Rezoning Transportation Analysis

Petition Number: 2020-099
General Location Identifier: 04705303

| Date | Description |
|----------|--------------|
| 08-20-20 | First Review |

REVISIONS:						REV REVISION DESCRIPTION DATE: CHANGED CHEC
DATE:	DESIGN BY:	DRAWN BY:	CHECKED BY:	APPROVED BY:		
	Mallard Creek Townhomes		Charlotte, NC		Bezoning Plan	
): 651032401			09/14/20

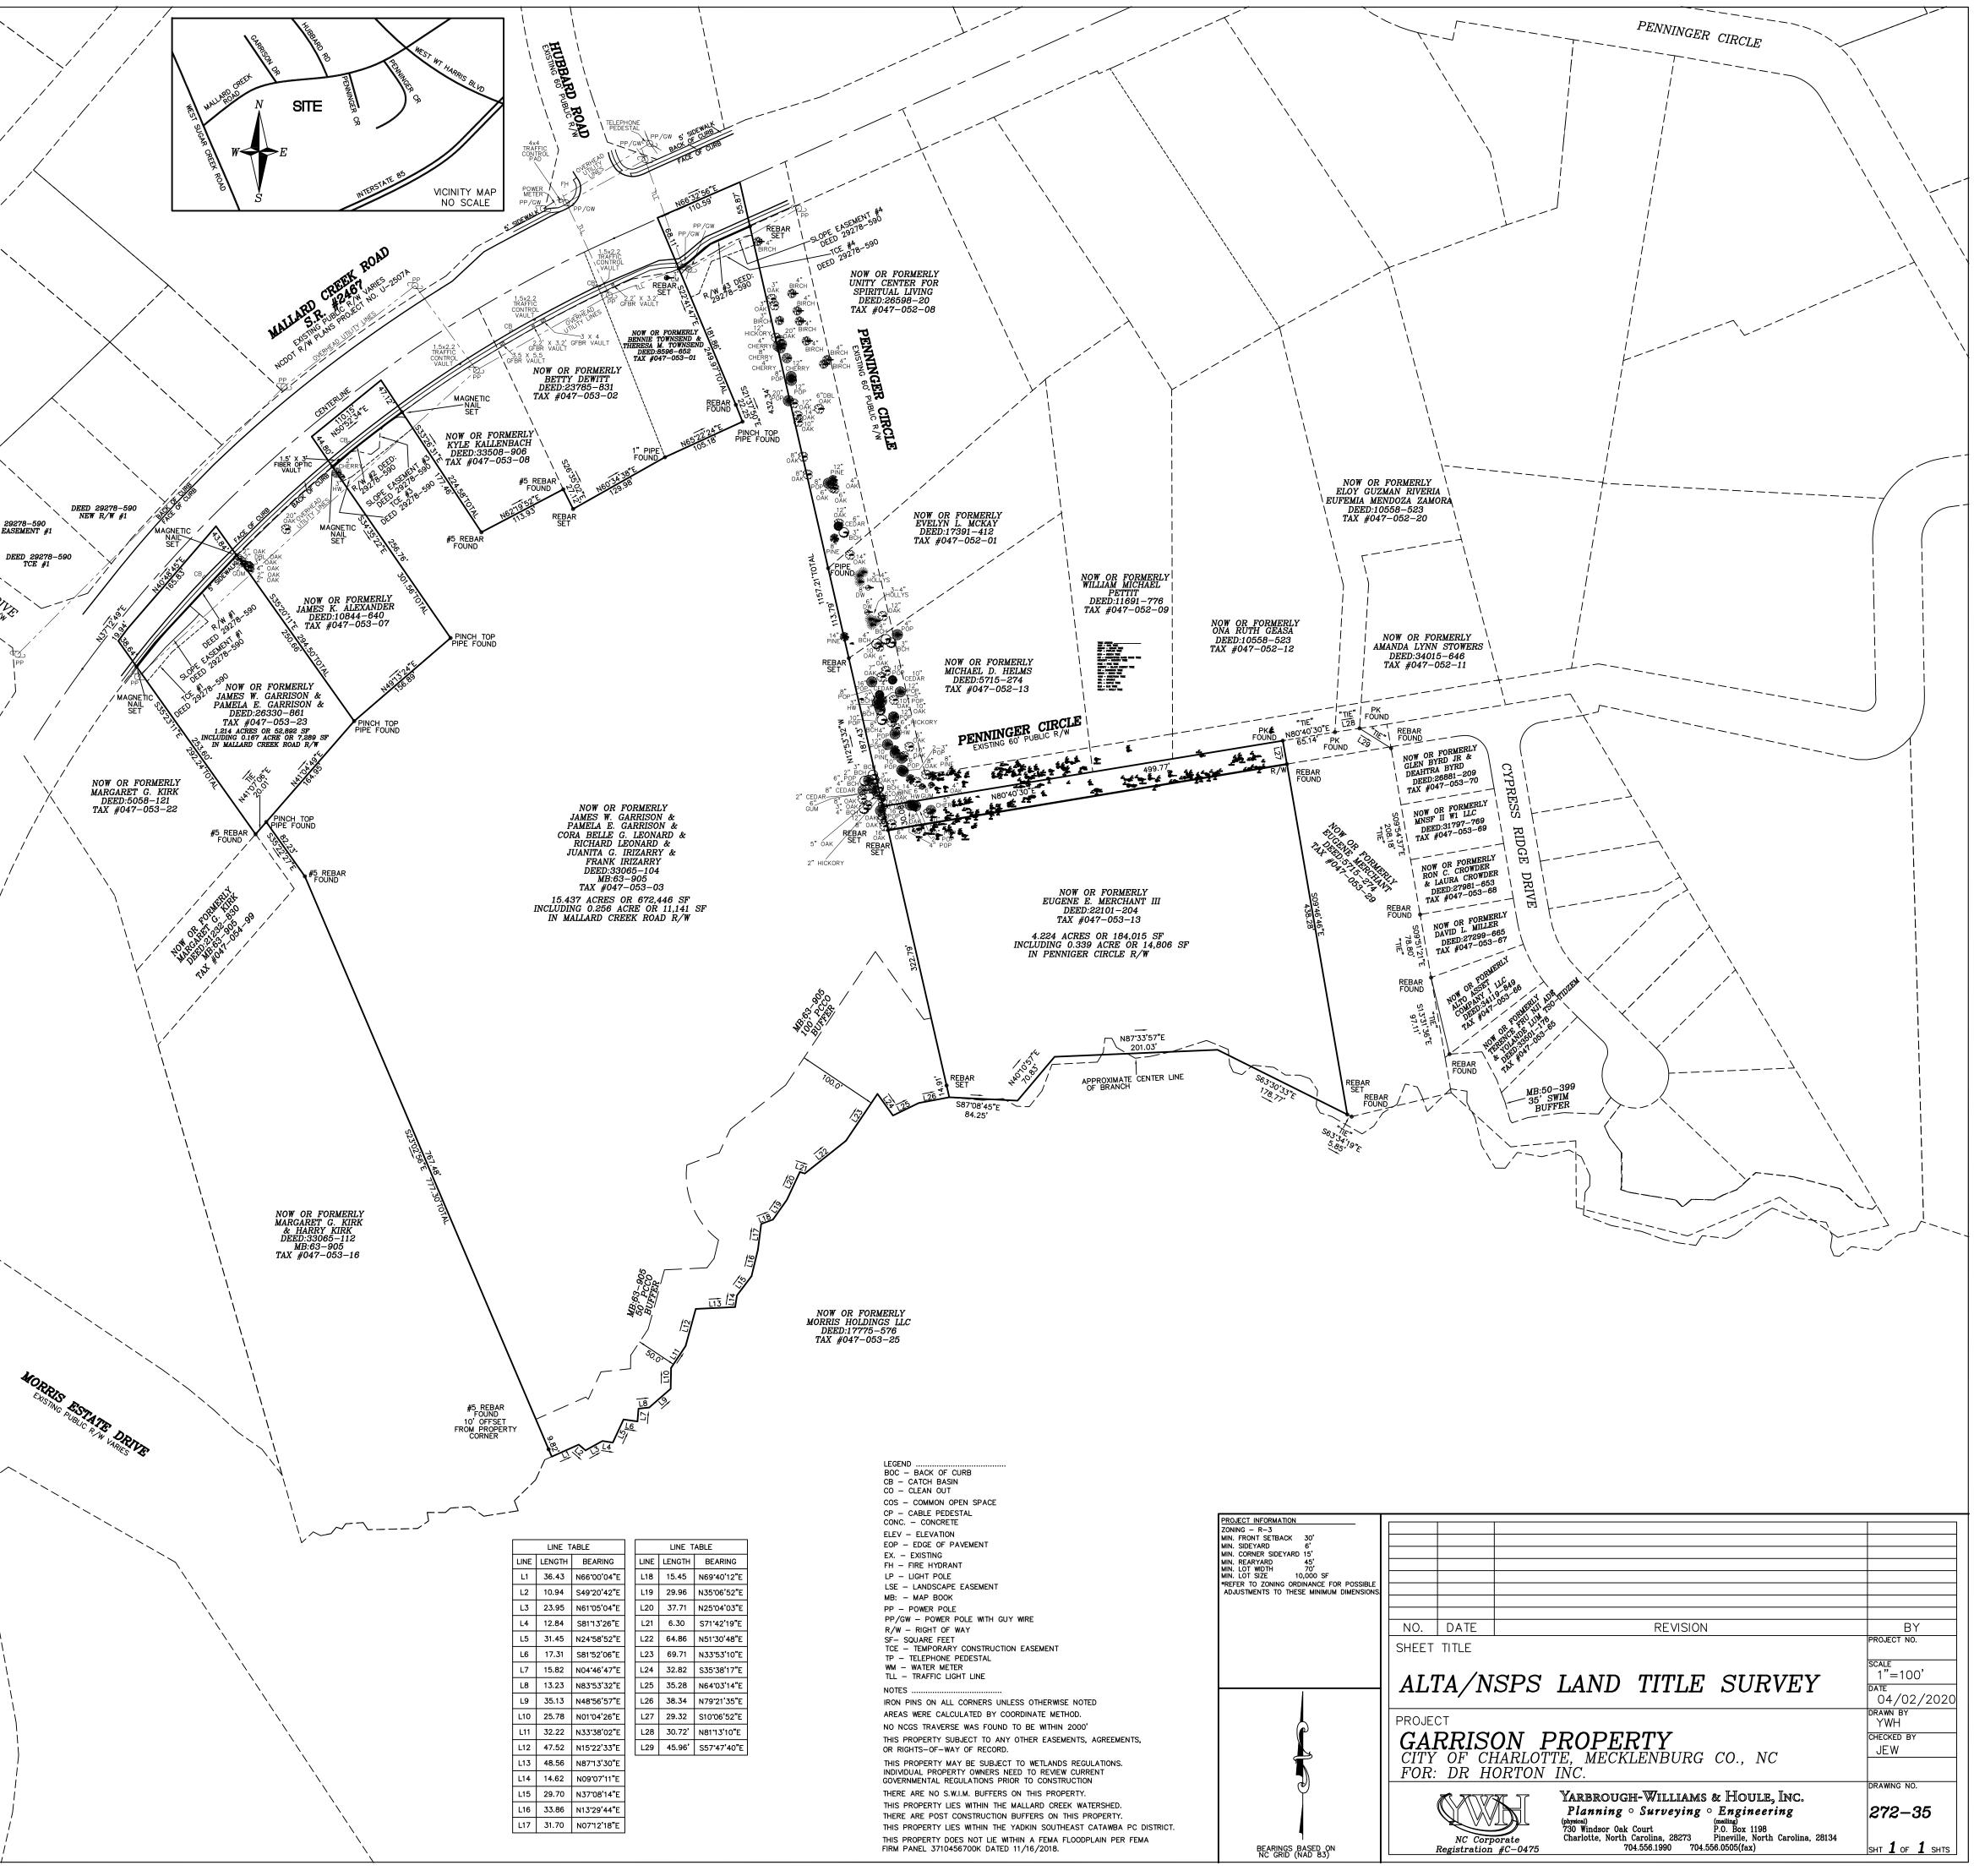
1. **Traffic Study** A Traffic Impact Study is not necessary for the complete review of this petition due to the site not generating more than 2,500 daily trips.
2. The petitioner should revise the site plan and conditional note(s) to clarify whether the residential local street will be constructed to USDG Residential Wide or Medium cross section, along the block of buildings 5 and 6, fronting Penningner Circle.

3. The petitioner should revise the site plan to include the roadway improvements that will be constructed within NCDOT's STIP (#U-2507A). In accordance with Charlotte BIKES, please provide an 8-ft planting strip and a 12-ft multi-use path, if sidewalk is not constructed within the STIP.
4. The petitioner should revise the site plan and conditional note(s) to confirm adequate intersection sight distance, according to CDOT's Sight Distance Policy, for access proposed on Mallard Creek Road.
5. CDOT requests the petitioner revise the site plan and conditional note(s) to provide rear alleys for access to public streets.
6. The petitioner should revise the site plan and conditional note(s) to restrict the proposed access on Mallard Creek Road to a right-in/right-out, with right-turn lane (100-ft storage with appropriate bay taper) on Mallard Creek Road at the proposed access location.

7. The petitioner should commit to dedicate an additional 2-feet of right-of-way from the proposed back-of-multi-use path, with the addition of the eastbound right-turn lane. The site plan should label and dimension the right-of-way from the road centerline.

- The petitioner should revise the site plan to add a note specifying dedication and fee simple conveyance of all rights of way to the City before the site's first building certificate of occupancy is issued. CDOT requests right of way set at 2' behind back of sidewalk where feasible.
- The petitioner should remove the proposed access on Mallard Creek Road, as shown below; NCDOT does not support an access at this location of Mallard Creek Road, in reference to the STIP's u-turn bulb-out. Please revise the site plan to provide adequate access for the existing single-family properties, using the proposed USDG Residential Medium/Wide section as proposed below. Please include sidewalk and planting strip on both sides of Penninger Circle.
